From: Planning
Subject: FW: Morgan's Farm development.

Subject: Morgan's Farm development.

Subject: Follow up email. Moran's Farm development.

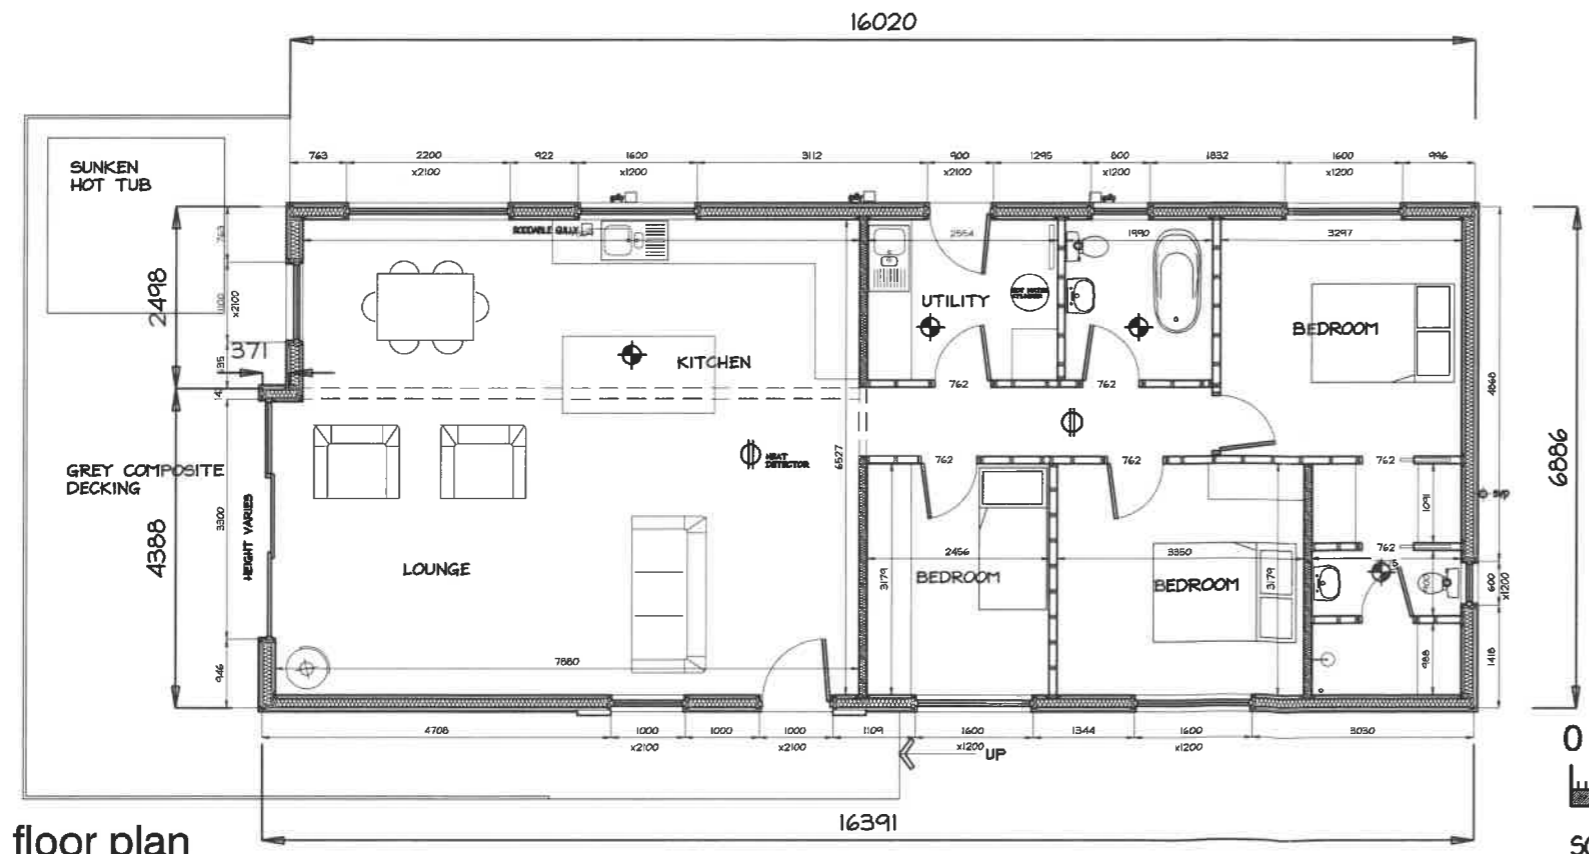
Hi,
I hope you are well. Please accept this email as further objection to the massive decking added to lodge 4 and the extra decking at lodge 2. We're also concerned that [Redacted] at [Redacted] haven't had their [Redacted]. So we'd like the council to enforce the removal of the hot tubs from lodges 2&4 and the deckings to be removed to give [Redacted] same privacy [Redacted]. It's unfair and punitive that you've (intentionally or unintentionally) given [Redacted]. And you've also allowed [Redacted] to install a fence way over 2m but again [Redacted] one for privacy.
I hope you can understand how it seems from our point of view and i add this to the [Redacted] complaint once this is all concluded.
